**MODIFICATION REQUEST:
MP10_0016 MOD 2**

***Scottish Hospital Seniors Housing and
Care Facility***

Environmental Assessment Report
Section 75W of the *Environmental Planning and
Assessment Act 1979*

April 2017

8 Level 8 Roof Plan
Scale 1:100
0 1 2 3 4

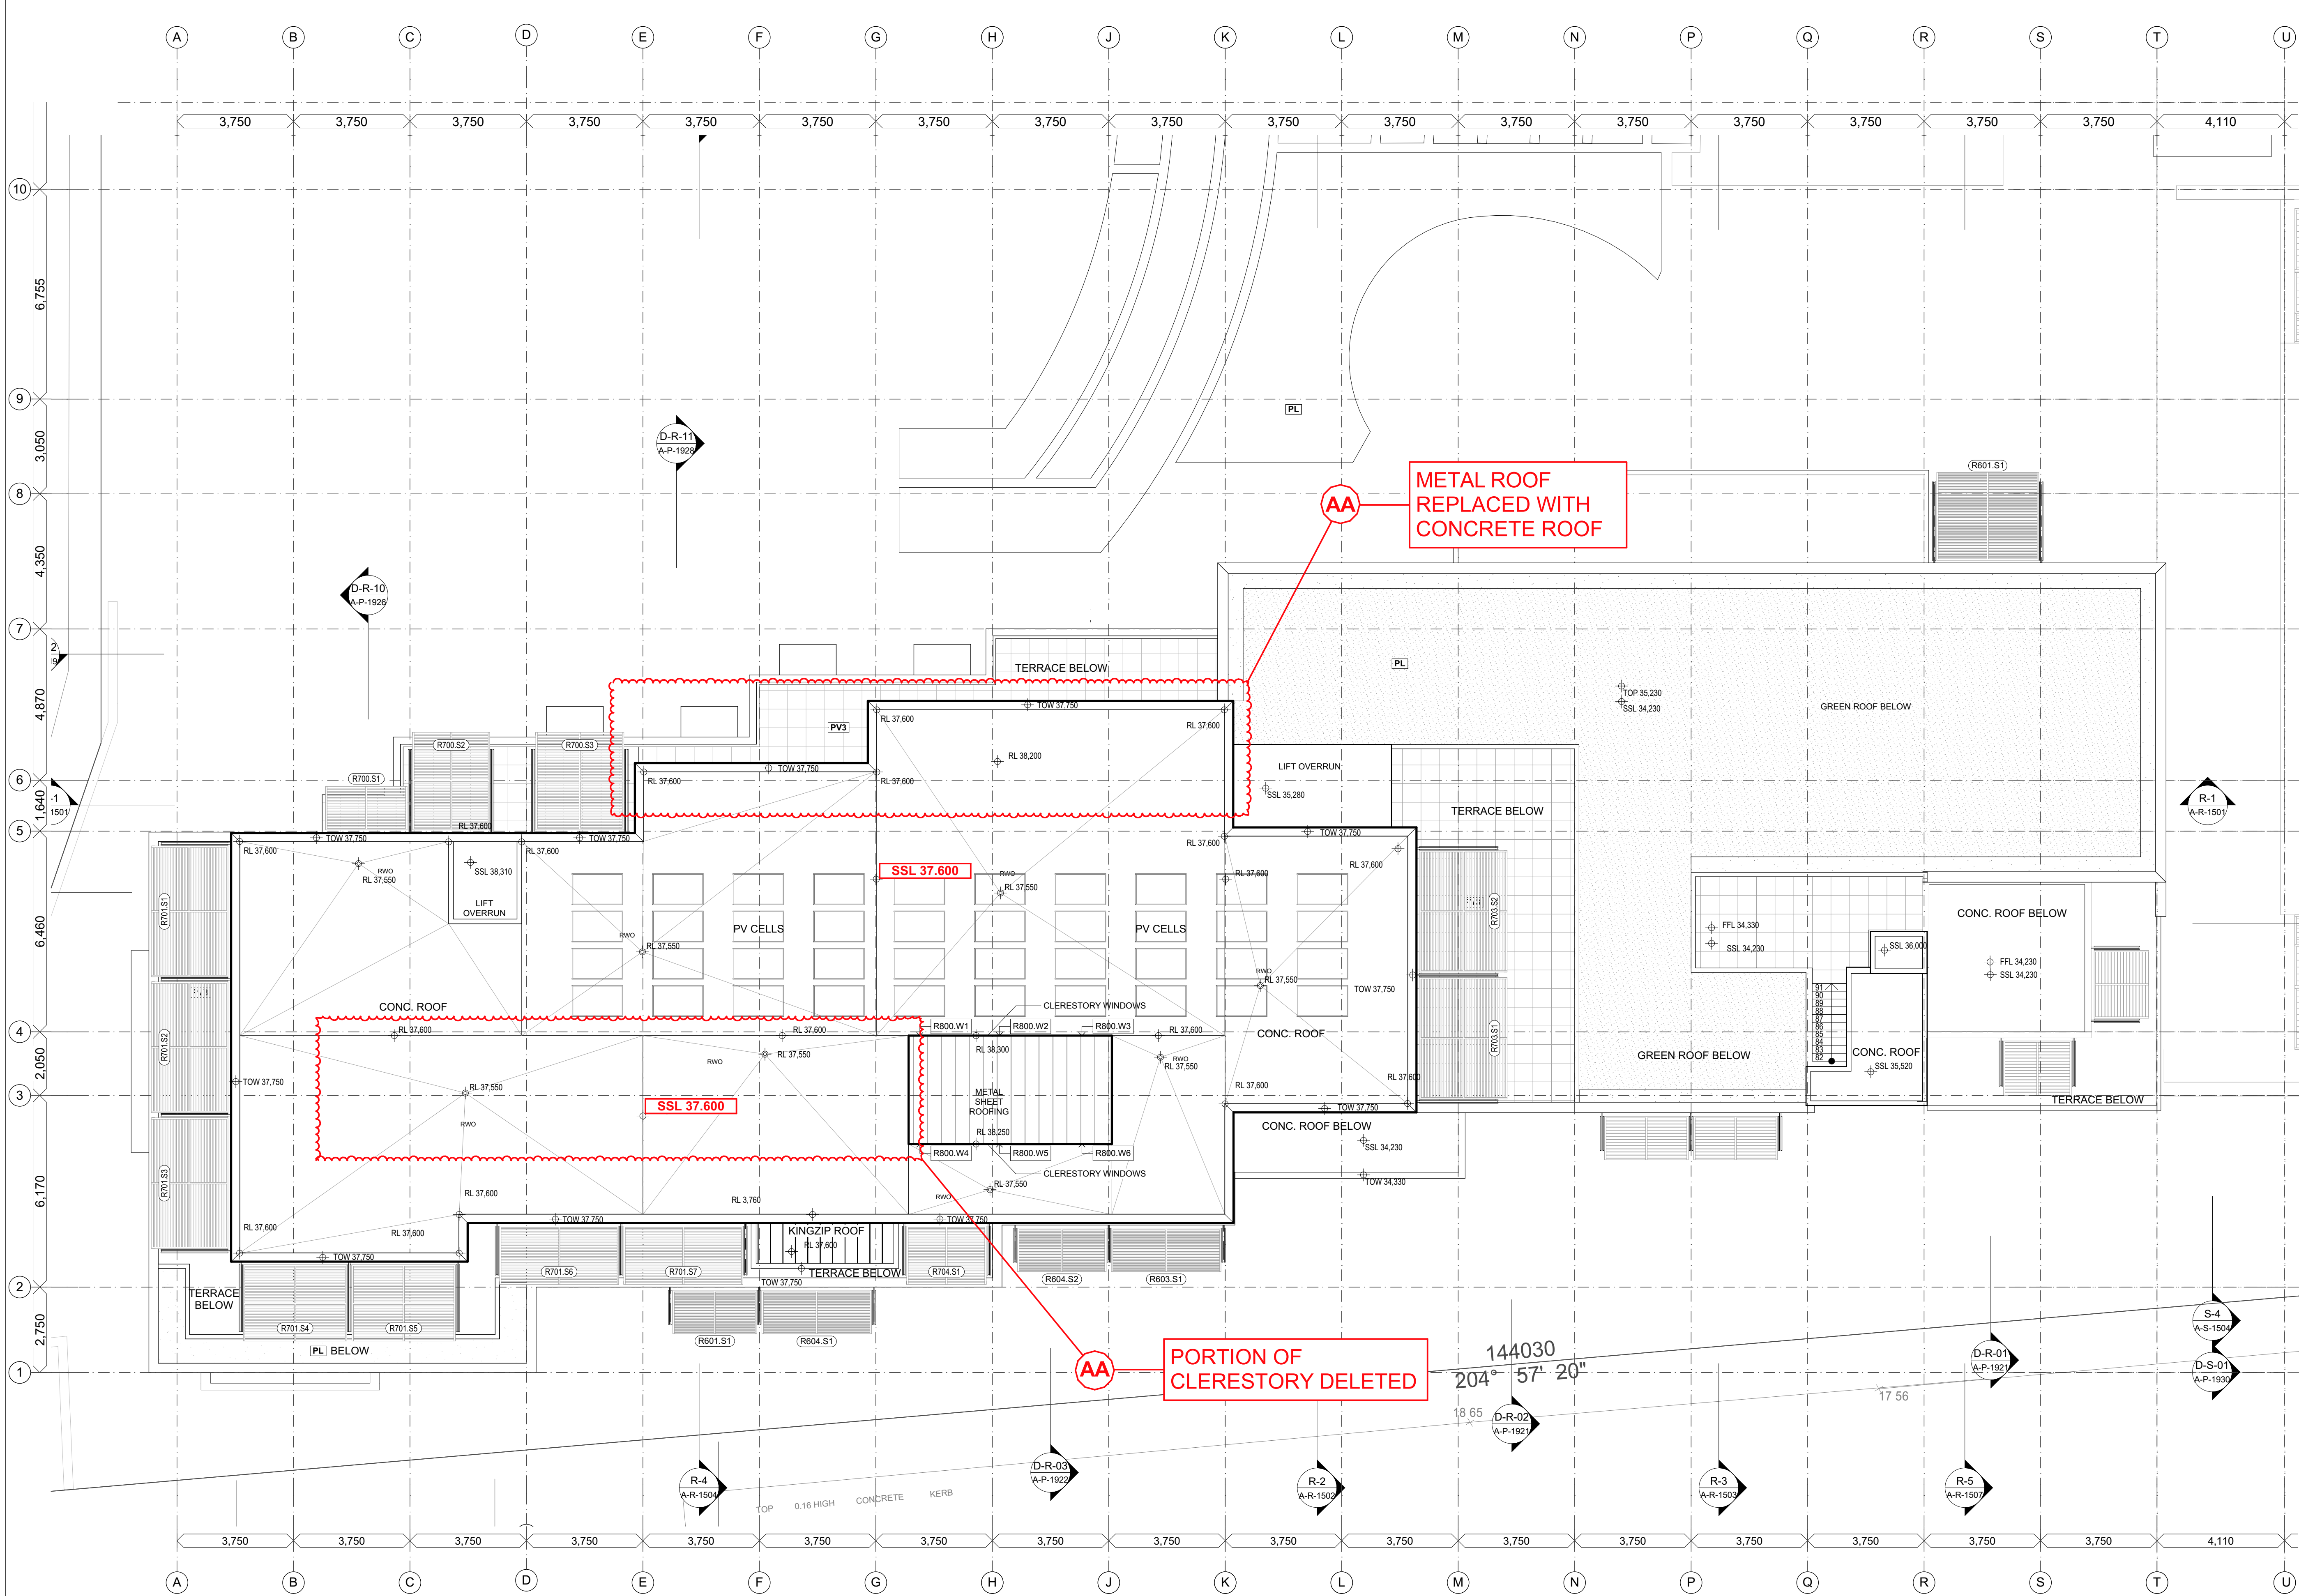
The Stephen Street RACF and Brown Street ILU building, as approved, provide clerestory windows. The Proponent is proposing partial deletion of the clerestory windows on the Stephen

Street RACF Building and deletion of all of the clerestory windows on the Brown Street ILU building (as shown in **Figure 10**).

The Proponent proposes to replace the approved metal roof of both the Brown Street ILU and Stephen Street RACF/ILU buildings with a concrete slab (**Figure 11**). The Proponent contends that this change in material will improve the longevity of the structure due to the site's proximity to the salt water of Sydney Harbour, as well as acoustic and thermal performance. It will also ensure ease of access to the roof for maintenance purposes. The return fascias on the building elevations will remain clad in metal in order to maintain the appearance of a metal roof when viewed from the public domain.

The Department supports the deletion of the clerestory windows and is satisfied that there will be no reduction in the overall design quality of the building.

The Department accepts the Proponent's justification for the change in roof material. The Department supports this aspect of the proposal as the use of cement will provide greater structural integrity to the roof, and the cladding of the fascias will ensure the buildings retain the appearance of a metal roof when viewed from the public domain.
